Application Ref: H18-0112-26

Proposal: **Conversion of redundant agricultural building for use as dog daycare**

Location: **8-9 Grange Farm, Hospital Road, Sutton Bridge**

ADDITIONAL INFORMATION REQUIRED

Job Title Proposed Barn Conversion at Land Adj. 8-9 Grange Farm, Hospital Road, Sutton Bridge For: M. Stone	Date October 2025	Drawn by AK
		Checked by SP
Drawing Title Planning Drawing Location and Site Plan	Job No. SE-2379	Sheet Size A1
	Dwg No. 1000	Revision C

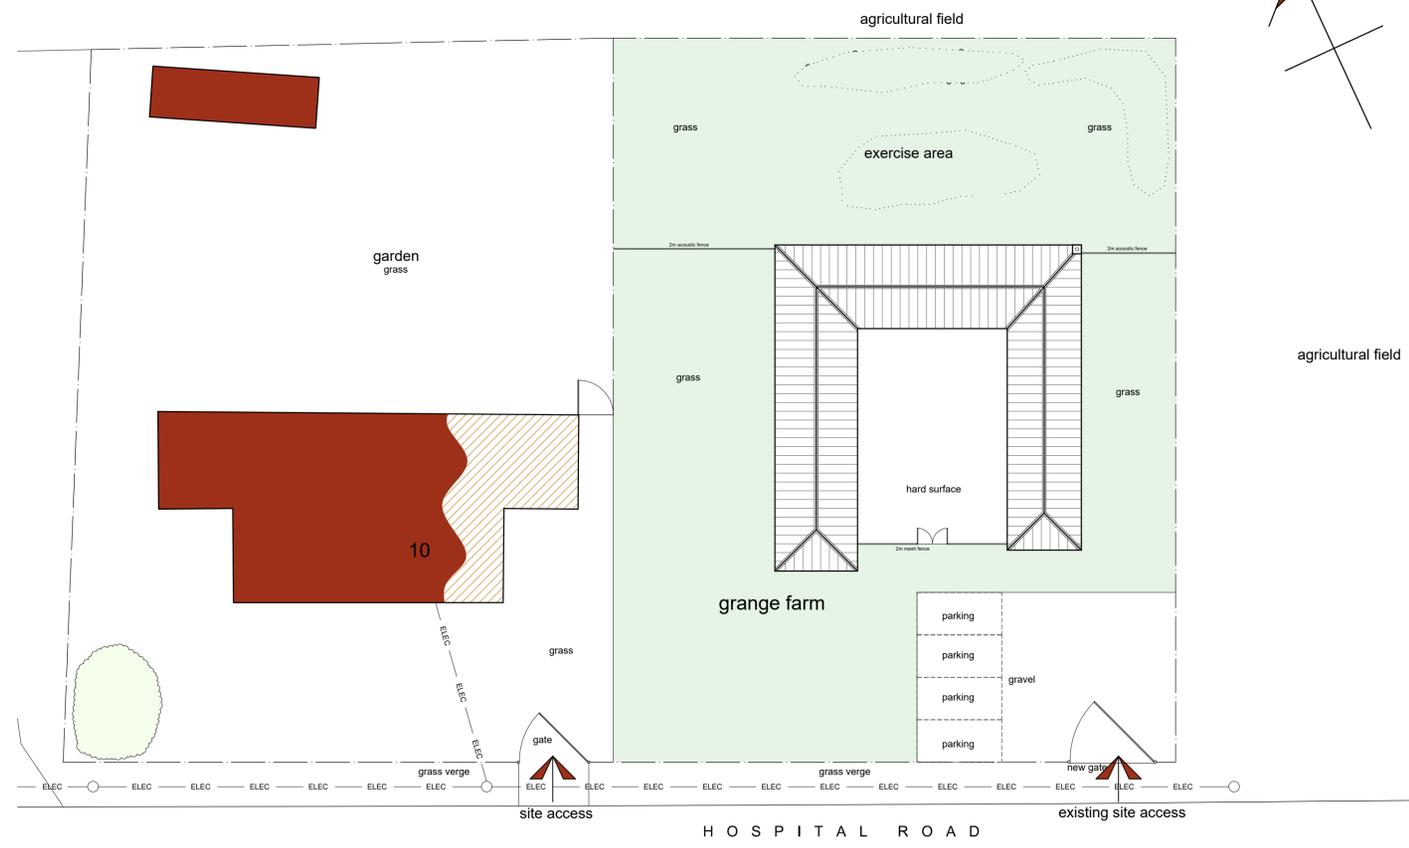
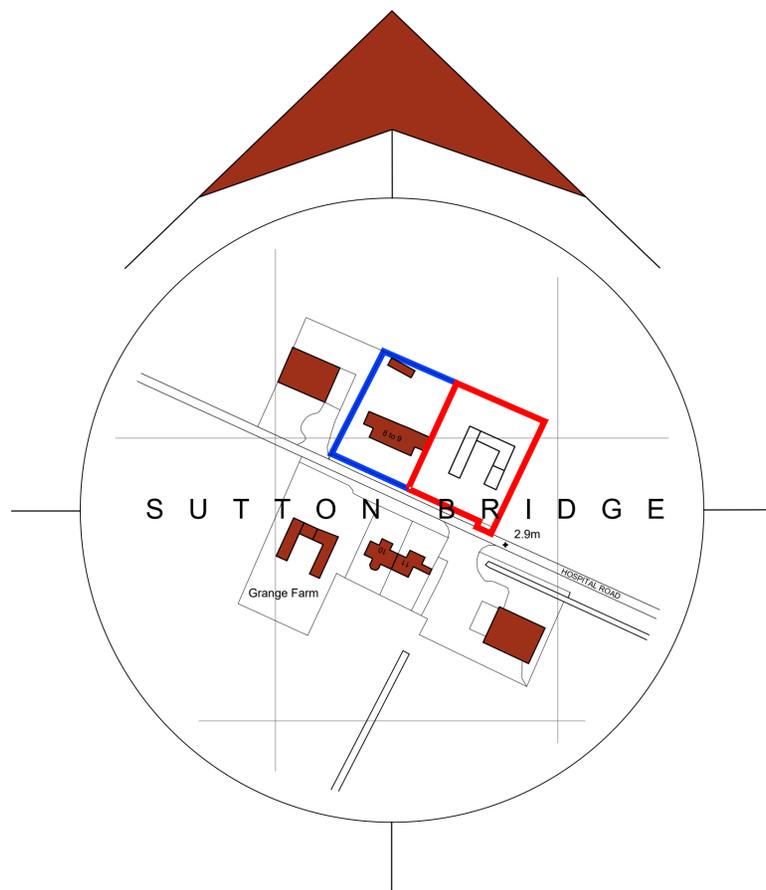
The access needs to be upgraded Lincolnshire County Council Specification, and it needs to be widened to 4.1m wide – both of which should be detailed on the proposed site plan.

Parking justification is required.
